# **Tees CCPP Project**

# **The Tees Combined Cycle Power Plant Project**

# **Applicant's Response to Examining Authority's Written Questions**

# **Examination Deadline 2**

Figure 7.3
Sensitive Human Receptors

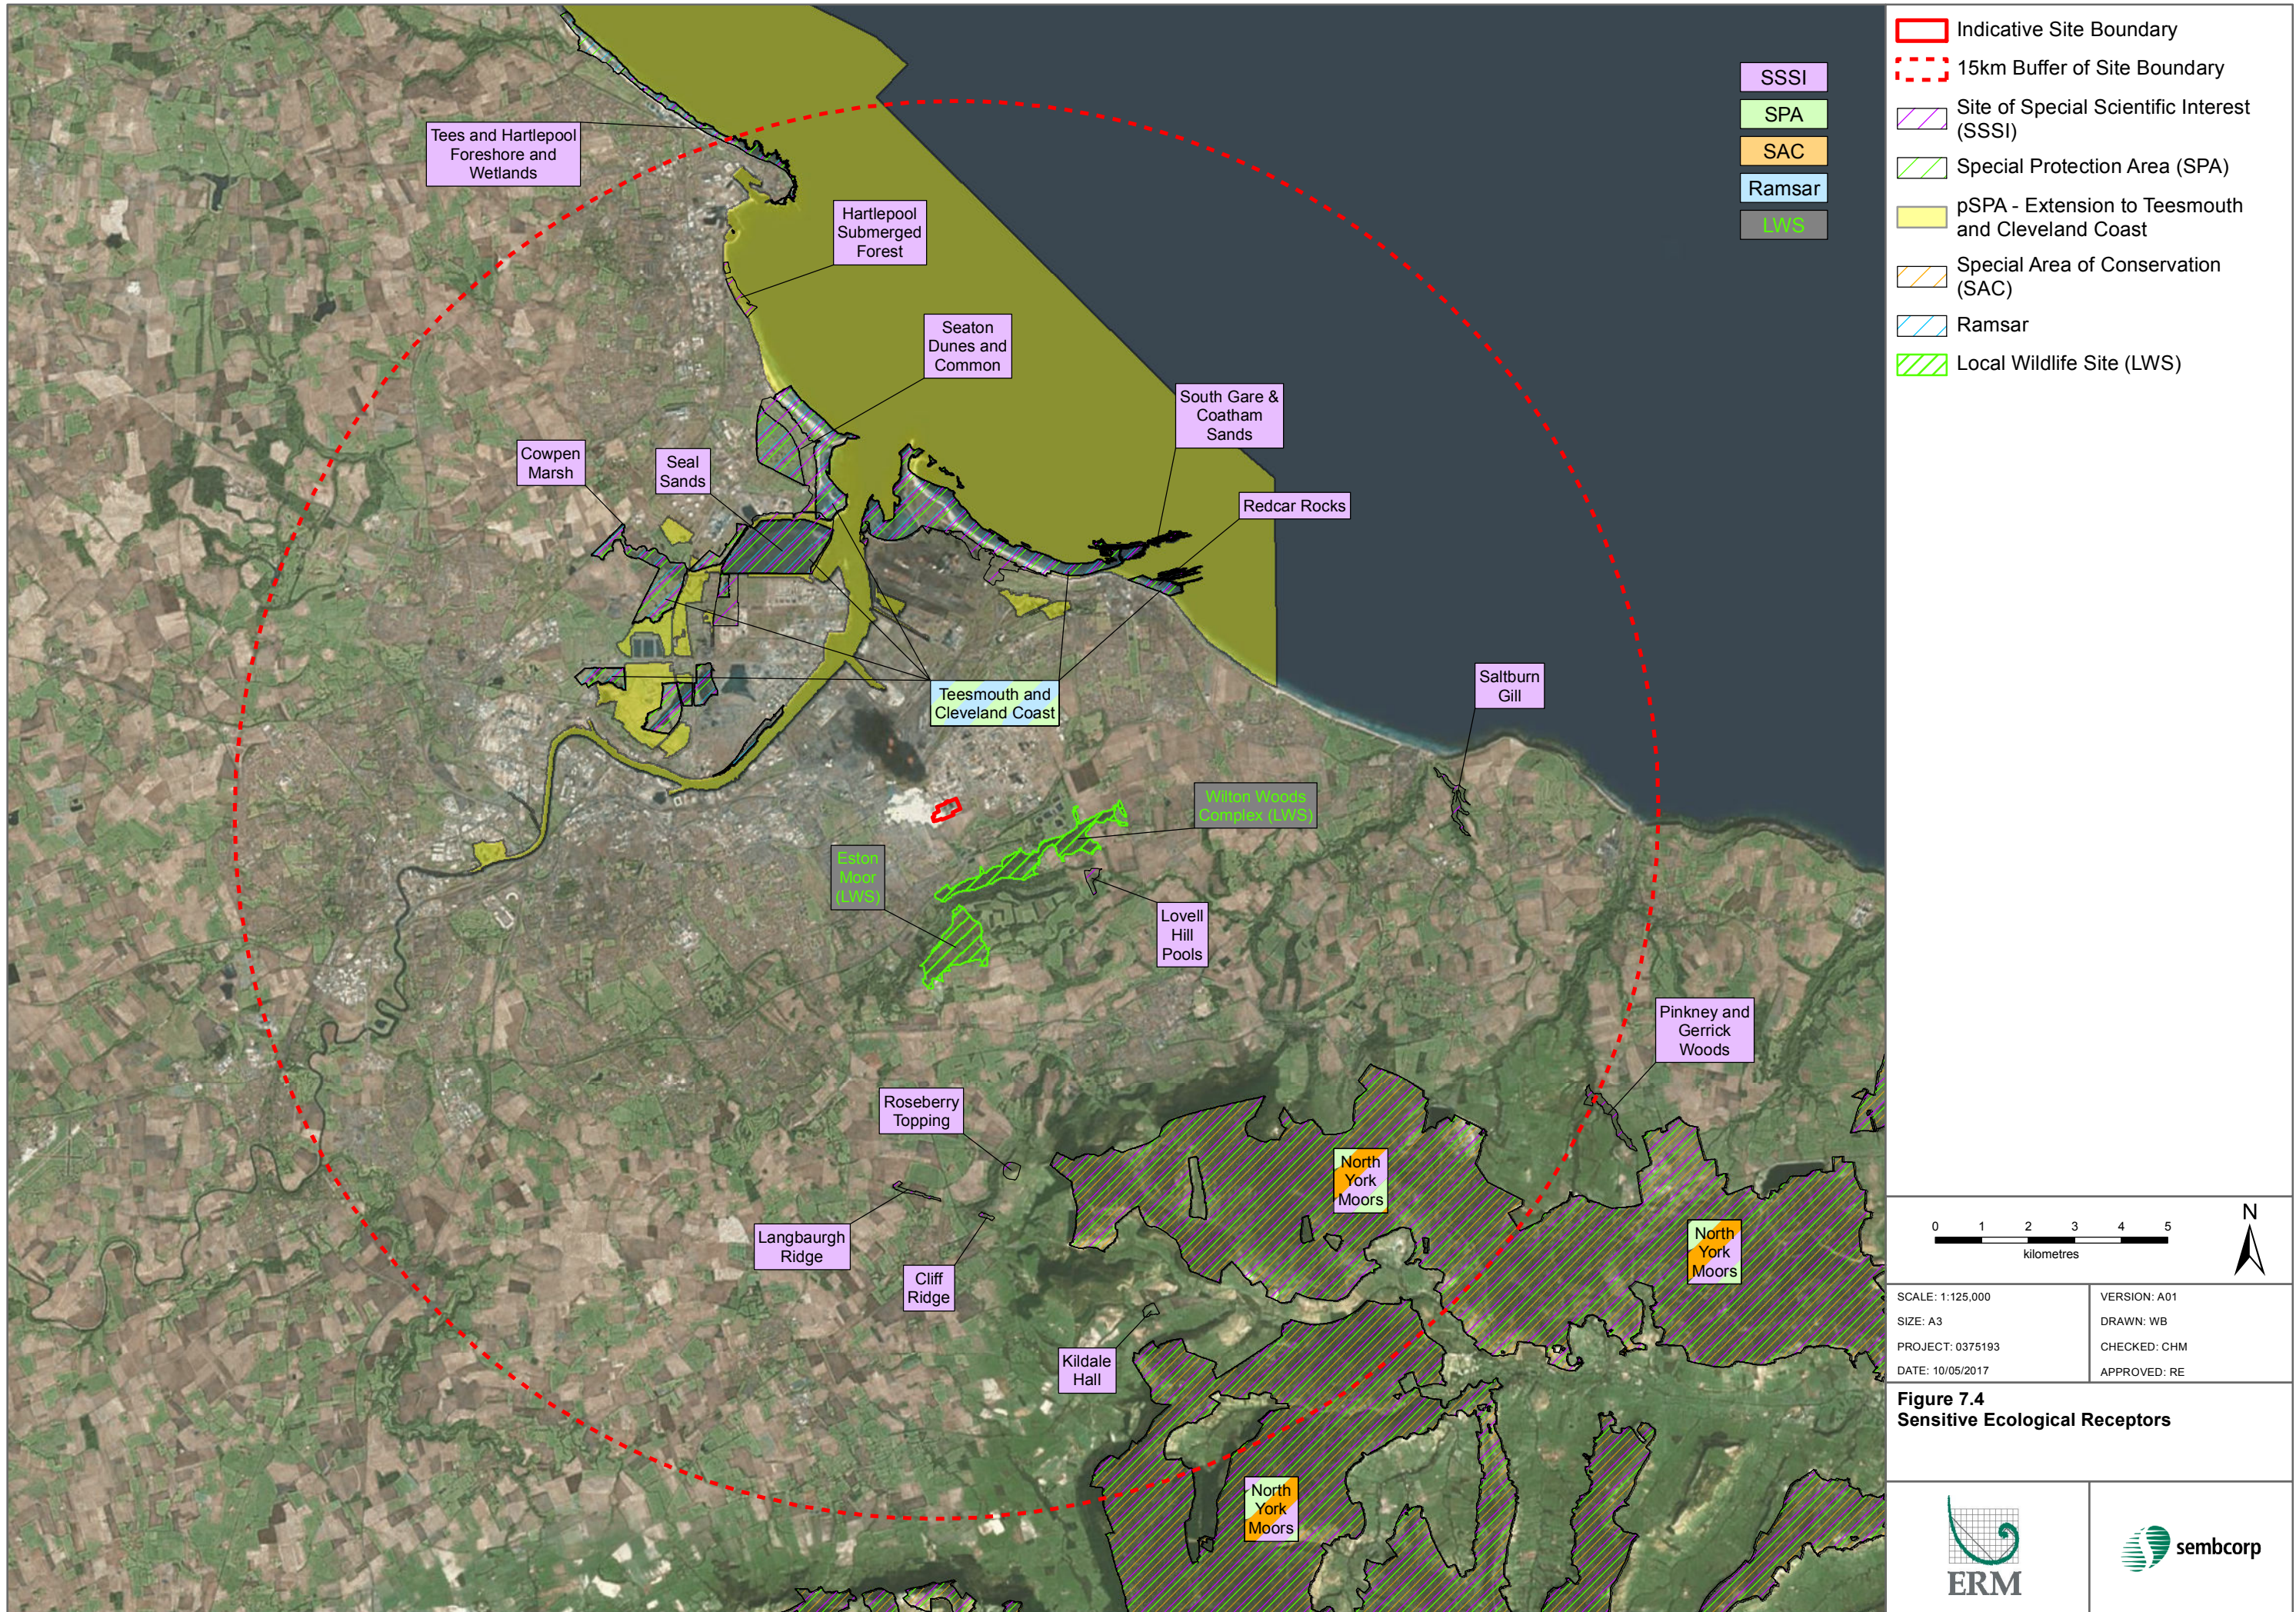
Q1.1.9	Applicant	Paragraph 7.82 of the ES [APP-049] states that the sensitive human receptors set out in Table 7.12 are shown in Figure 7.3. In fact the receptors shown in Figure 7.3 are reflective of those presented in Table 7.14 rather than Table 7.12. Please clarify.	Table 7.12 [APP-049] sets out relevant sensitive human receptors. Table 7.14 [APP-049] setstations which are in the locations of sensitive receptors. The two are largely, but not complIt is therefore correct that the monitoring locations are shown in Figure 7.3 [APP-049], not the sensitive receptors.
Q1.1.10	Applicant	Whilst acknowledging that the majority of land uses to the north of the application site, as described in paragraph 7.83 of the ES [APP-049] are industrial, why did the assessment not consider the nearest sensitive human receptors to the north / north west particularly when Figure 7.1 shows the prevailing wind direction to be mainly from the south west?	The air quality standards and guidelines for the protection of sensitive human receptors apply assessment considered the maximum impacts predicted anywhere outside the Project site bo for sensitive human receptors includes sensitive human receptors to the north and northwest, [APP-049]. These figures illustrate that the maximum impacts occur to the northeast of the p south away from sensitive human receptors.
